City of Sydney

17 August 2012

**RE: STUDENT ACCOMMODATION ON BLOCKS 3B, 3C & 10, CENTRAL PARK,
CHIPPENDALE (FORMER CARLTON UNITED BREWERY SITE) (MP11_0090)**

DRAWING NO A-203	REVISION

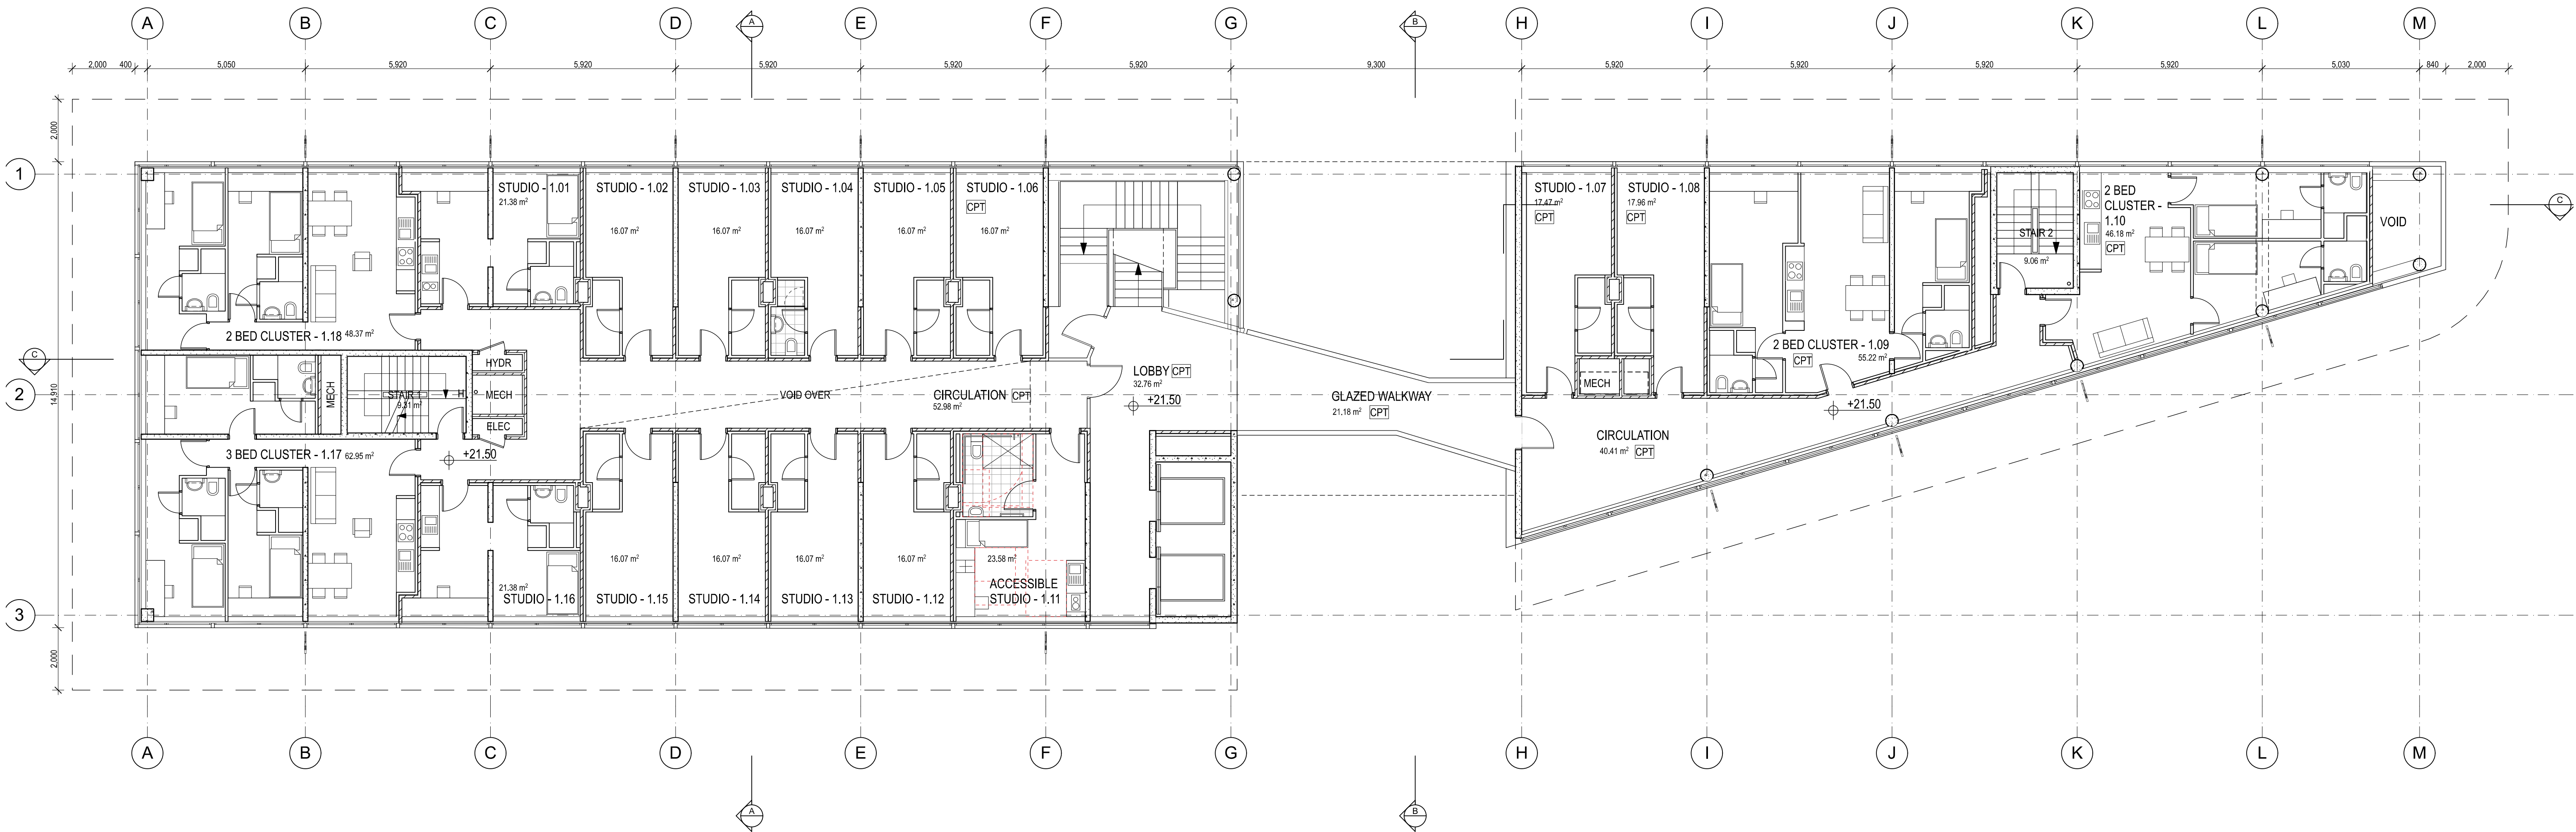
Whilst no objection is raised to the design rationale, in its current form Blocks 3B and 3C share a single lobby, with a 3 metre wide walkway connecting the buildings at Level 1 of the development. The inclusion of this walkway reduces the clearance height in parts of the through-site-link from 6.5 metres to 3.75 metres.

- delete the walkway at Level 1 and/or provide a further ground floor access to Block 3C to allow the clearance height of 6.75 metres to be maintained;
- where the Department is of the view that the removal of the walkway is not possible, that the walkway at Level 1 be finished with a highly transparent frameless glazed curtain to maximize views and light through to the through-site-link.

1 SOUTH ELEVATION

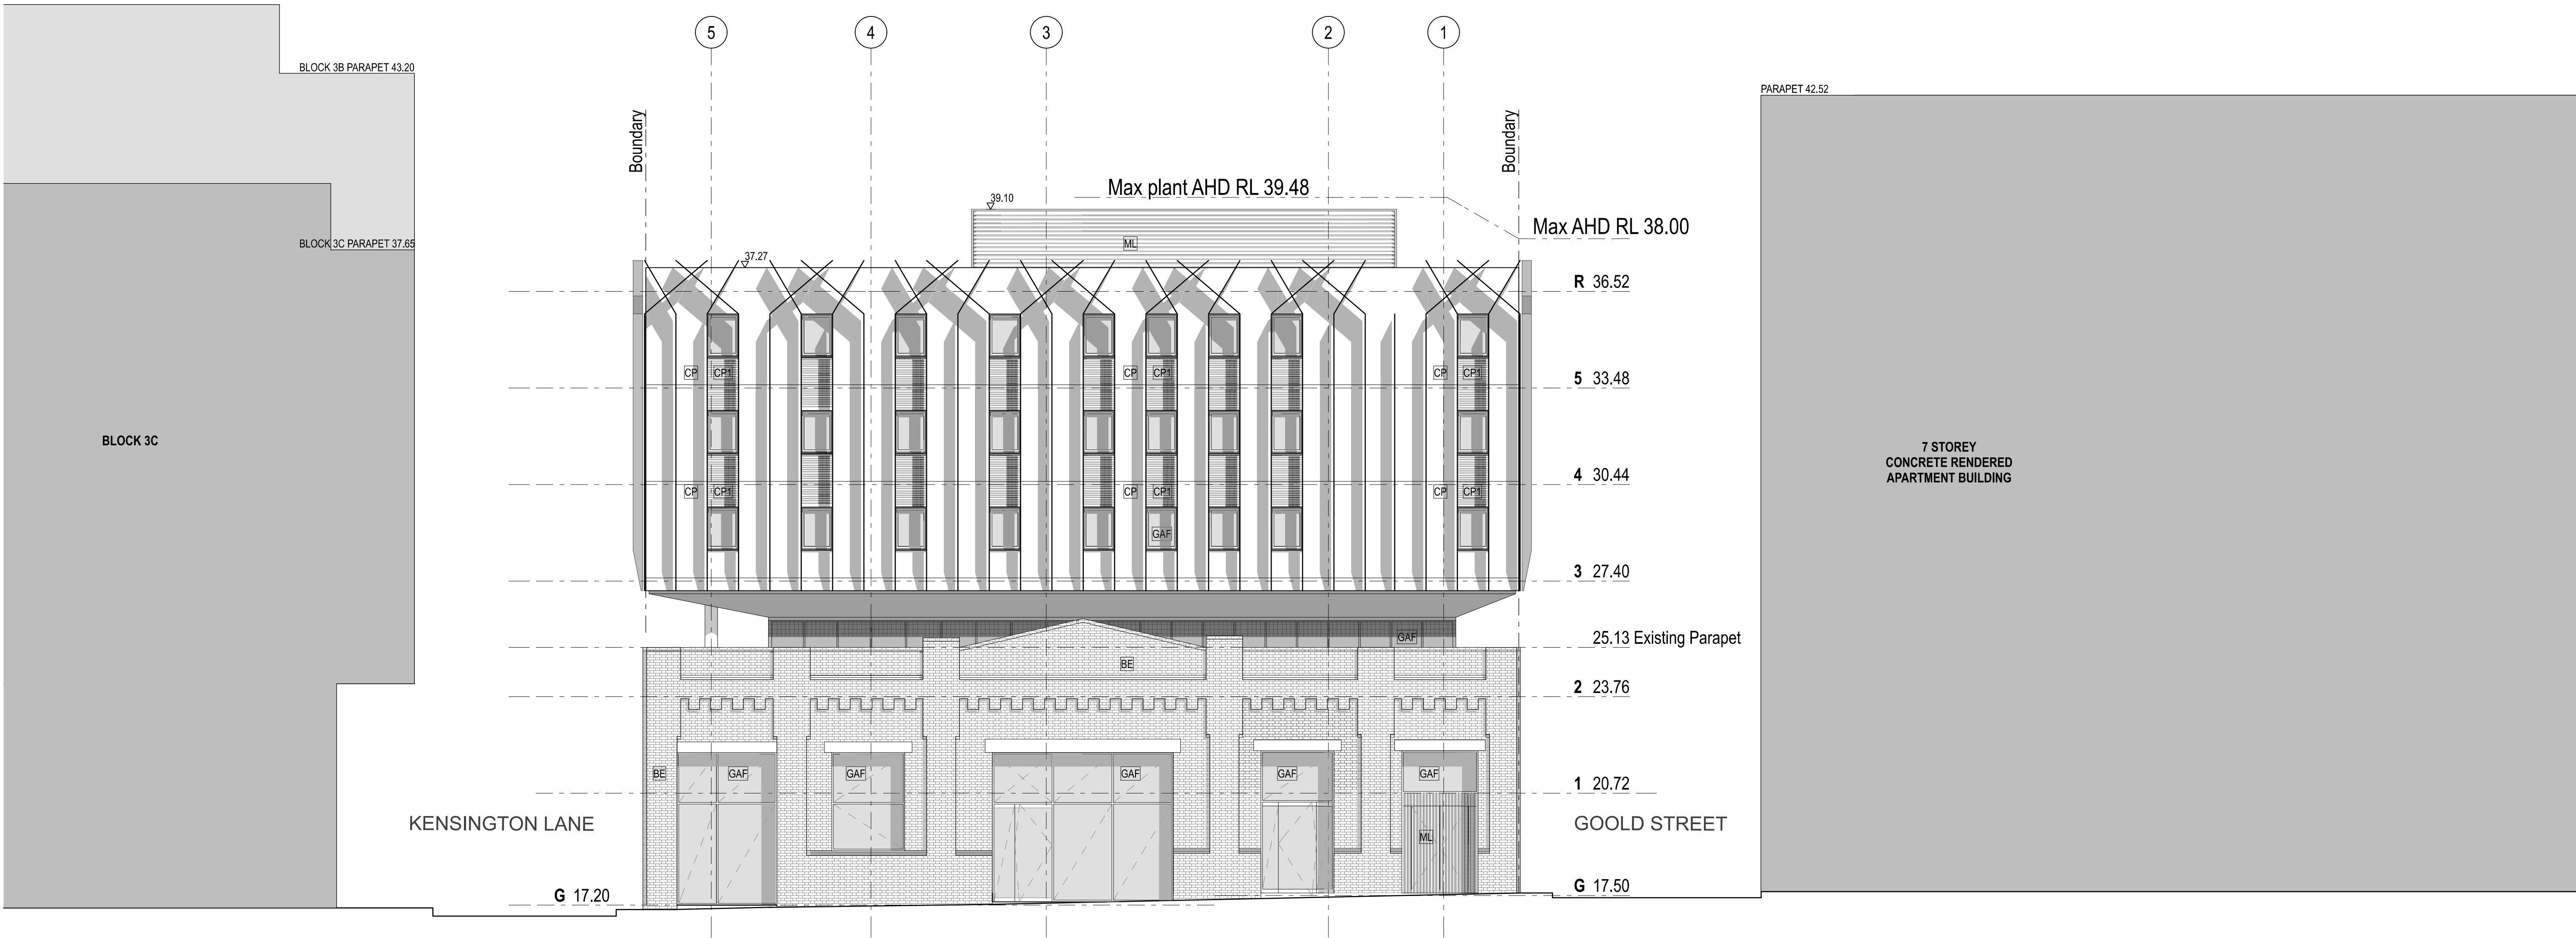
It is noted that the separation distances between the proposed building on Block 10 and the adjoining developments located to the south and east (on the opposite sides of Outram and Goold Streets, respectively) are non-compliance with the Residential Flat Design Code. The proposed nil setback of the proposed building at Levels 3 to 5 and the narrow separation with adjacent buildings creates privacy issues.

Whilst it is understood that design features are proposed to mitigate impacts, the proposed use of internal fixed louvres is not supported as it is considered to adversely impact on internal amenity of the student rooms through reducing outlook, light and potentially ventilation.

It is recommended that the Department, either through the submission of amended plans or via appropriate condition should ensure the provision of operable louvres (or venetian blinds) and operable windows to the northern, eastern and southern elevations. This solution would provide sufficient visual privacy when required, whilst enabling fresh air and outlook to the bedrooms. The provision of internal curtains or blinds on the western elevation is considered to be acceptable.

Figure 11 – Proposed eastern elevation of Block 3B and 3C

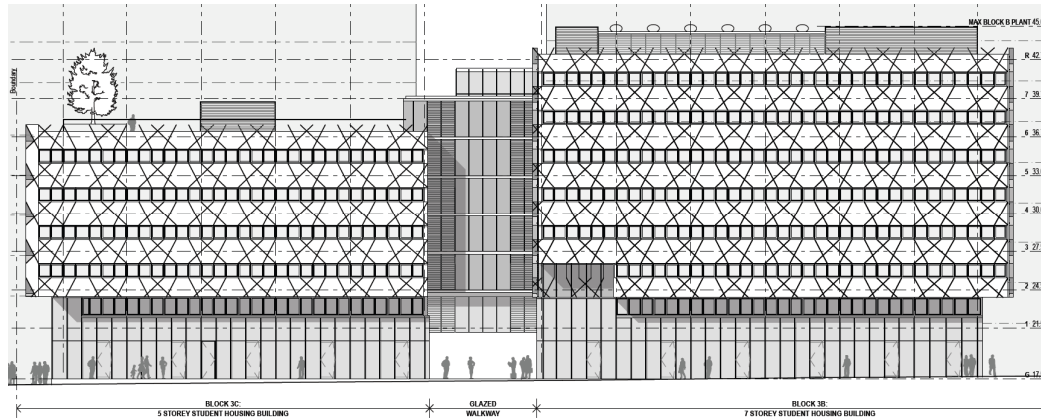
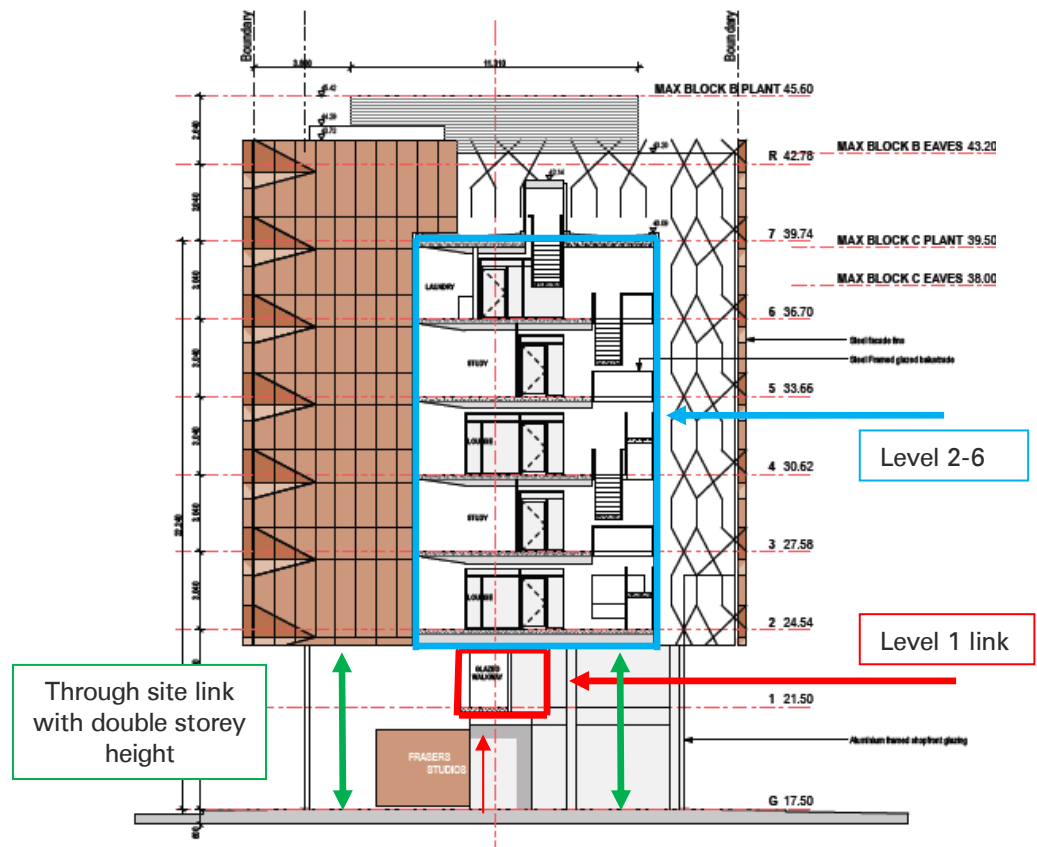
The through-site link between Blocks 3B and 3C does not comply with the building envelope approved in the Concept Plan. The Concept Plan envelope shows a potential link between Blocks 3B and 3C from Level 3 and above. In the current form the proposal includes linkages from Levels 1 and above. This proposed change will reduce the clearance height of the through-site link from 10 metres high to approximately 6.5 metres high.

Further to the concerns to the proposed linking walkway between Blocks 3B and 3C regarding the through-site link clearance heights, concern is also raised that the modifications proposed from the approved Concept Plan result in substantial additional bulk and lack of separation and differentiation between Blocks 3B and 3C.

It is recommended that the Department consider requiring amendments to the proposal to maintain the form of the link approved in the Concept Plan as this would provide greater visual separation and differentiation between the two blocks and would assist in reducing the bulk of the building.
